**WELWYN HATFIELD COUNCIL – DEVELOPMENT CONTROL**  
**DELEGATED REPORT**

<b>PLANNING APPLICATION No:</b>	<b>N6/2007/575/FP</b>
<b>ESTATE MANAGEMENT APPLICATION No:</b>	<b>W6/2007/0577/EM</b>

SIDE ELEVATION

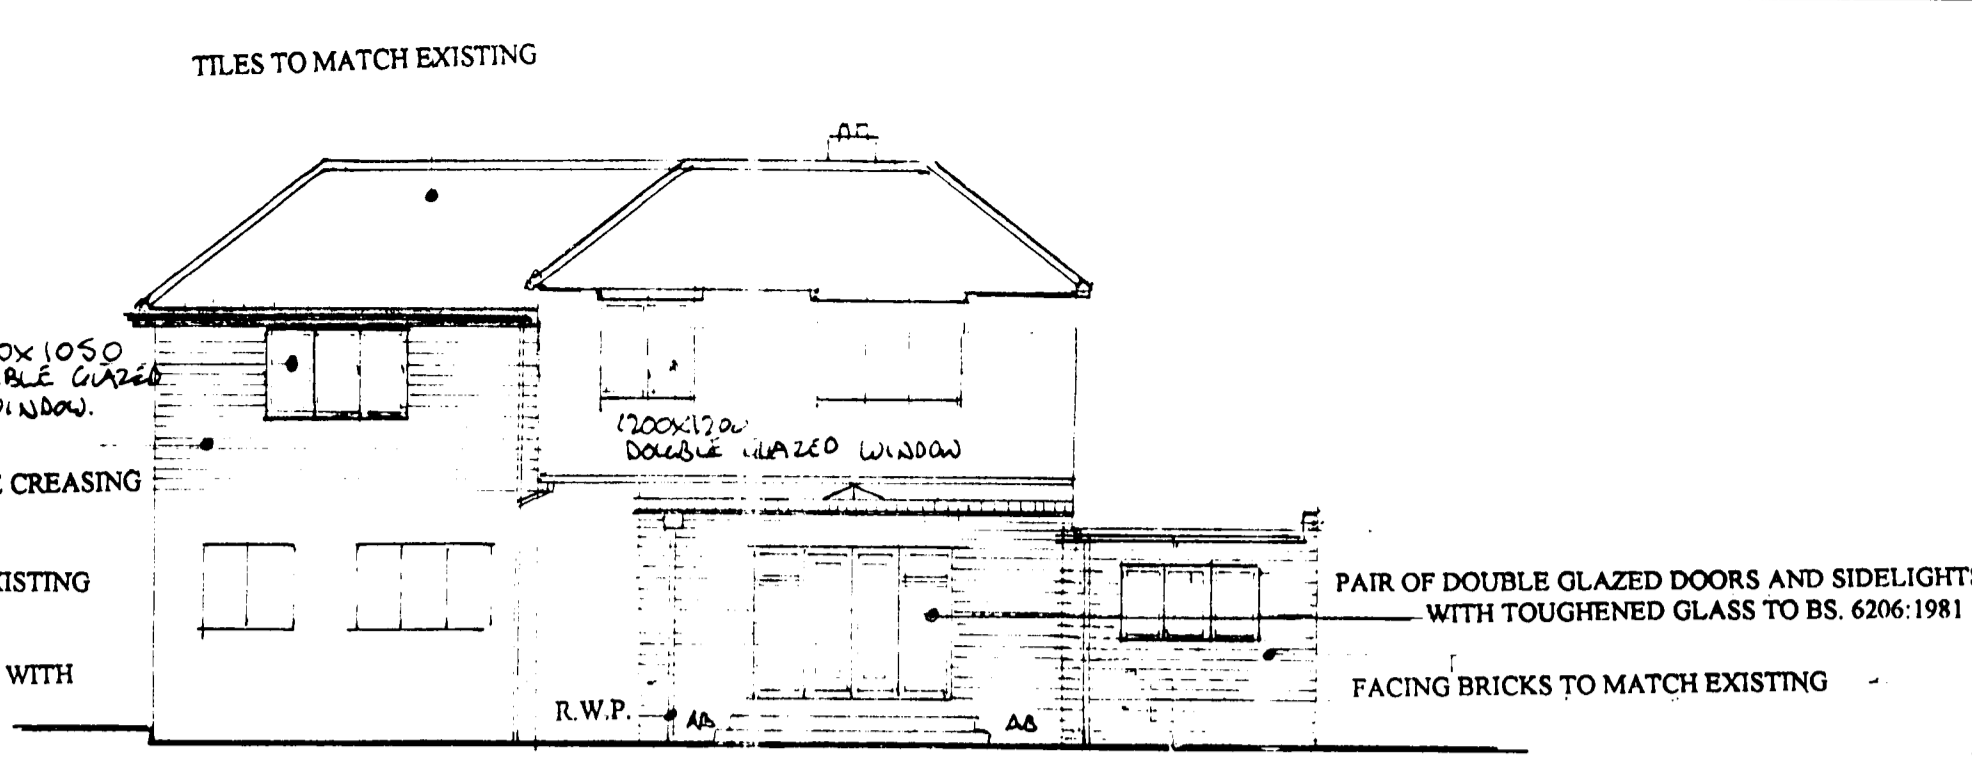
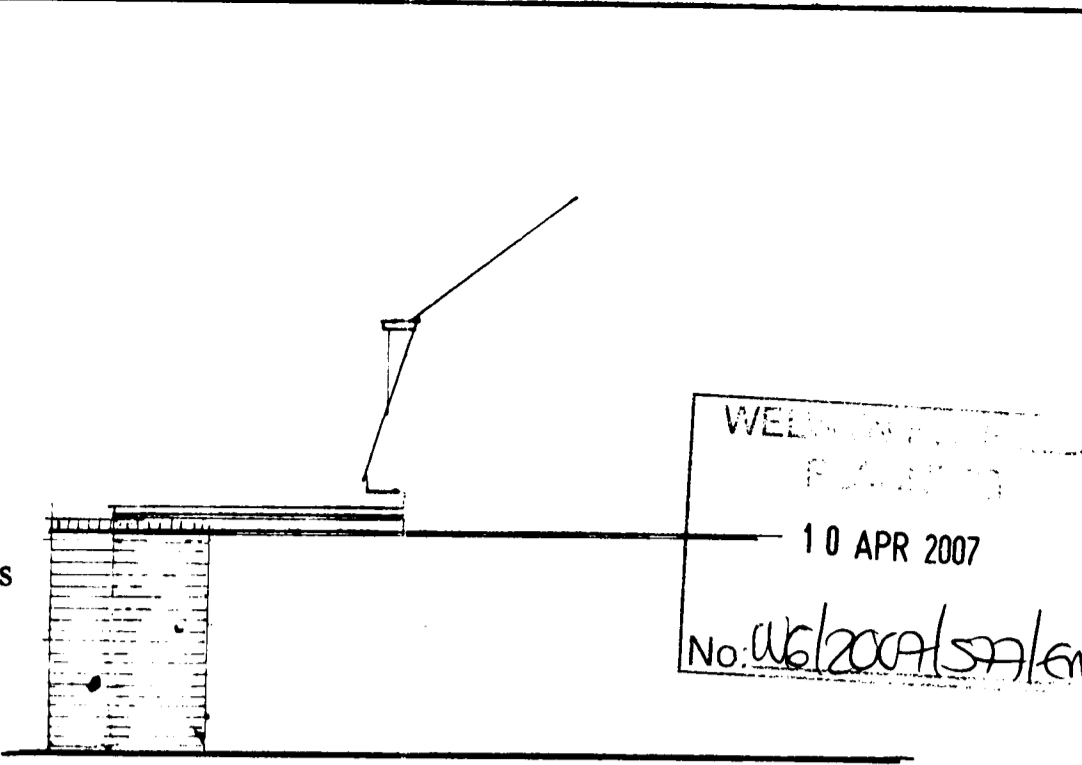
The proposed ground level rear extensions would protrude from the building line of the existing property. When taking into account the orientation of the site, the scale of the extension and the height, it is considered that the development would be unlikely to have any impact on the light that is afforded to the neighbouring property to an extent that would justify the refusal of the application on those grounds. Similarly the location of the proposed first floor extension is considered to be at a significant distance from the adjoining property No.19 Roundwood Drive to maintain the privacy and light currently afforded to it. Although there is a first floor window proposed the staggered nature of the properties and the glazed nature would maintain the amenity to the adjoining property. A condition will be included to maintain a glazed window to the first floor on the western elevation, and a condition for no further first floor windows to be included to the subject extension facing No.19.

- 1. C.2.1            3 Year Time Limit
- 2. C.5.1            Samples of materials to be submitted and agreed
- 3. C.7.9            Obscure glazing to first floor window on the western elevation
- 4. C.7.10           No further windows to be included to subject western elevation

GROUND FLOOR PLAN

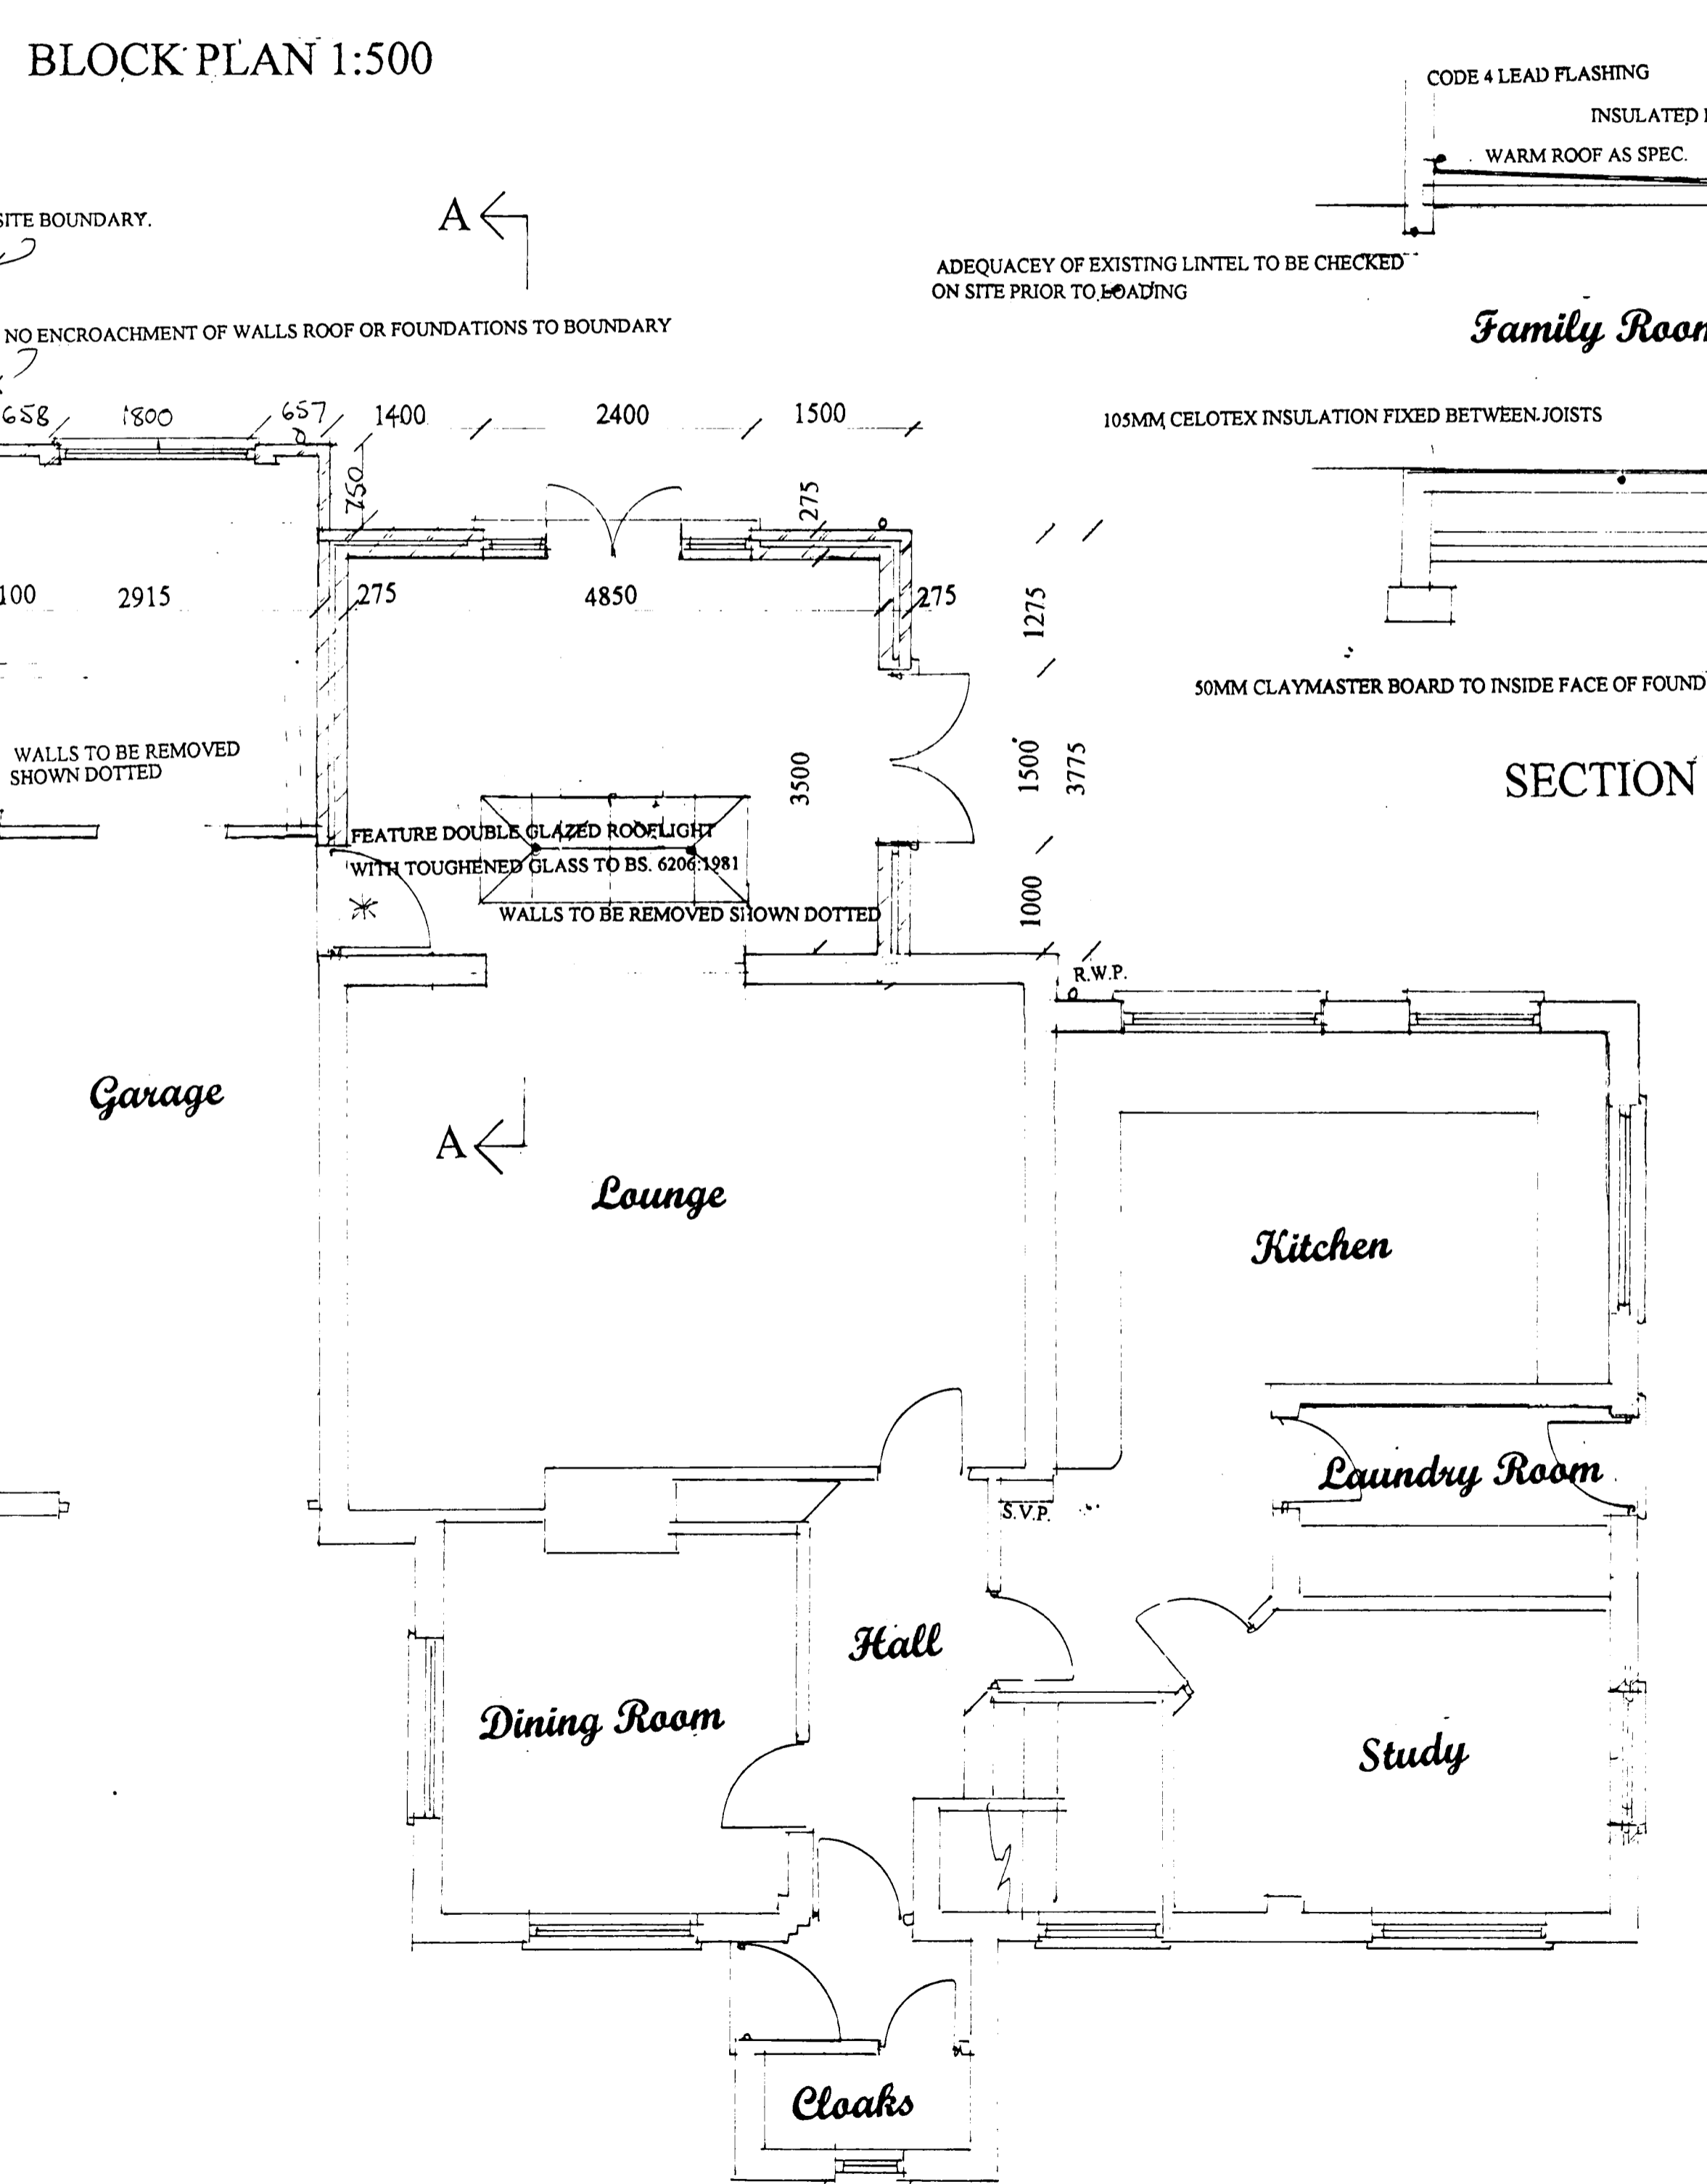
1. The Council's Supplementary Design Guidance outlines that residential extensions should have an appearance that is subordinate to the main dwelling in terms of scale and mass. In this instance it is considered that the revised ground level extension and incorporation of a further rear extension to ground would satisfy the character of the property and the immediate character to this part of Welwyn Garden City. Although both extensions would extend further to the rear than the adjoining property No.15 Roundwood Drive, the flat roof finish and ground level nature would balance the special character

FIRST FLOOR PLAN

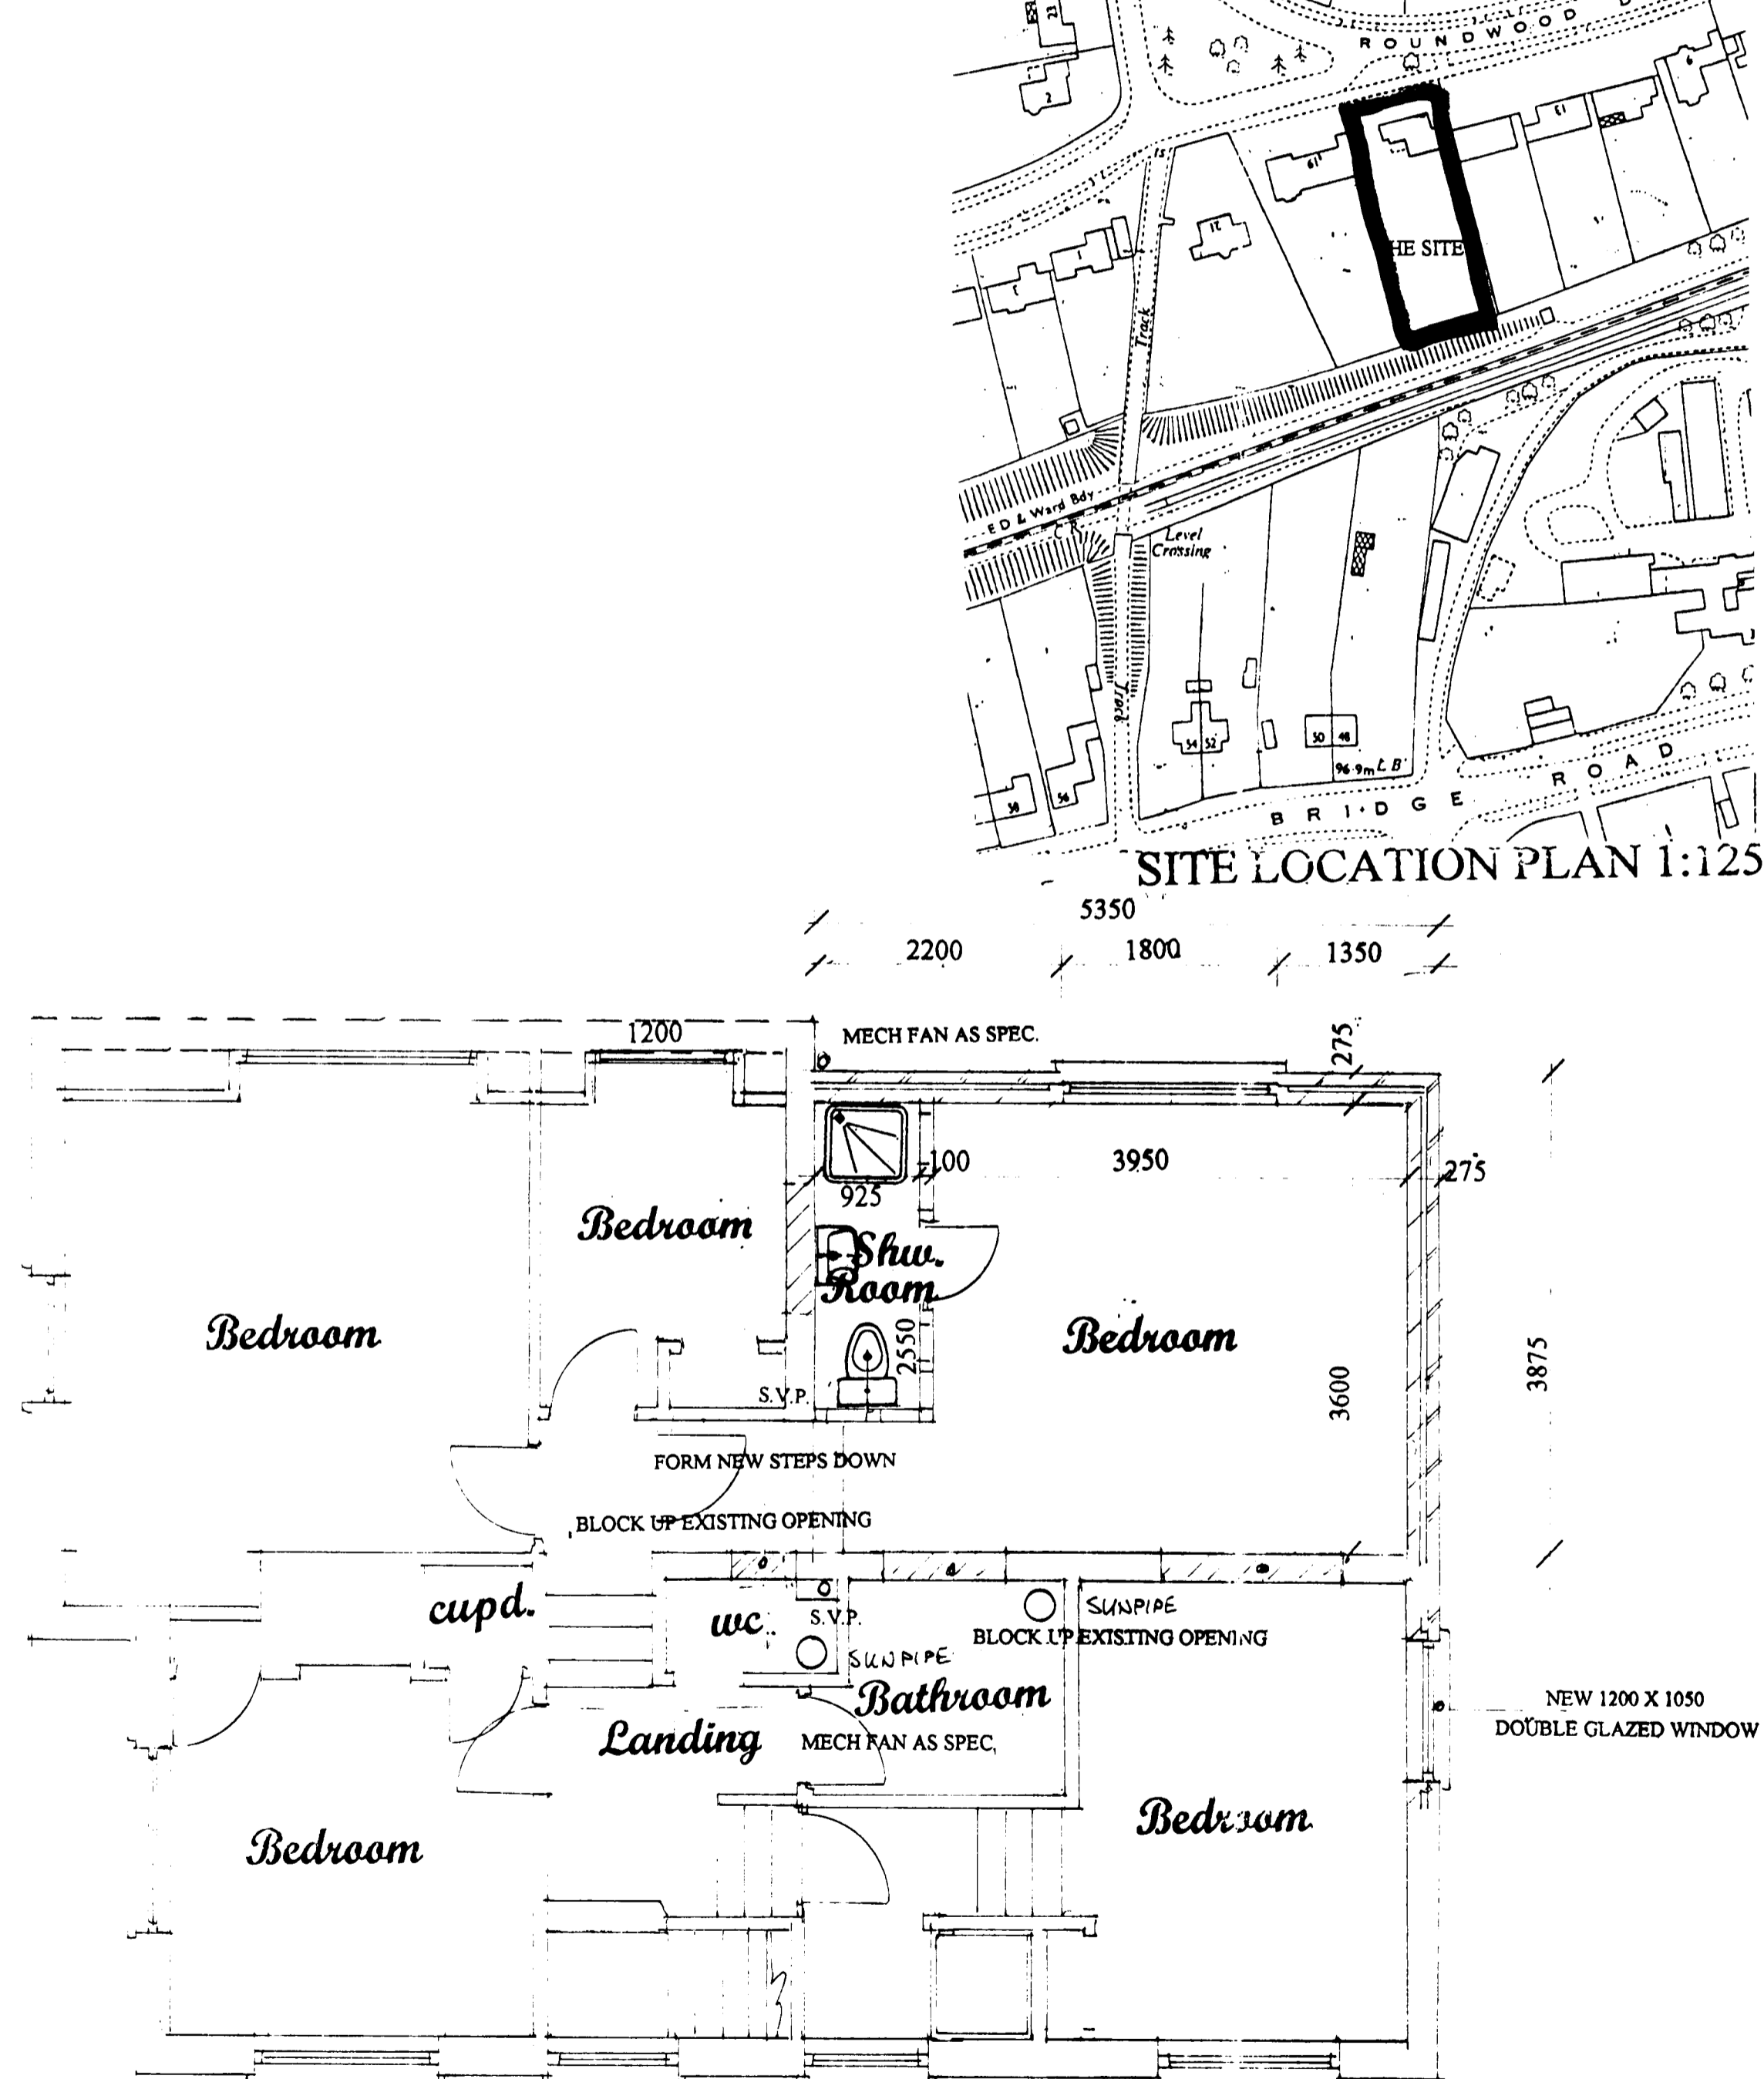
BEAMS – Agree with the ground level extensions, however would not approve the first floor extension as it would create excessive building bulk to the dwelling and not be in keeping with the conservation designation.

The part of the application for the first floor extension would be considered to have a greater impact on the subject property and conservation area. However the existing building line to the side and rear of the existing property would be maintained and the hipped roof form is considered to be in line with the style of the parent dwelling. The first floor extension would have limited impact to the street character with the orientation of the site and the dense vegetation currently dominating the front of the property in line with the location of the extension. Therefore it is considered the architectural features of the parent property would be maintained as part of this application and should be recommended for approval.
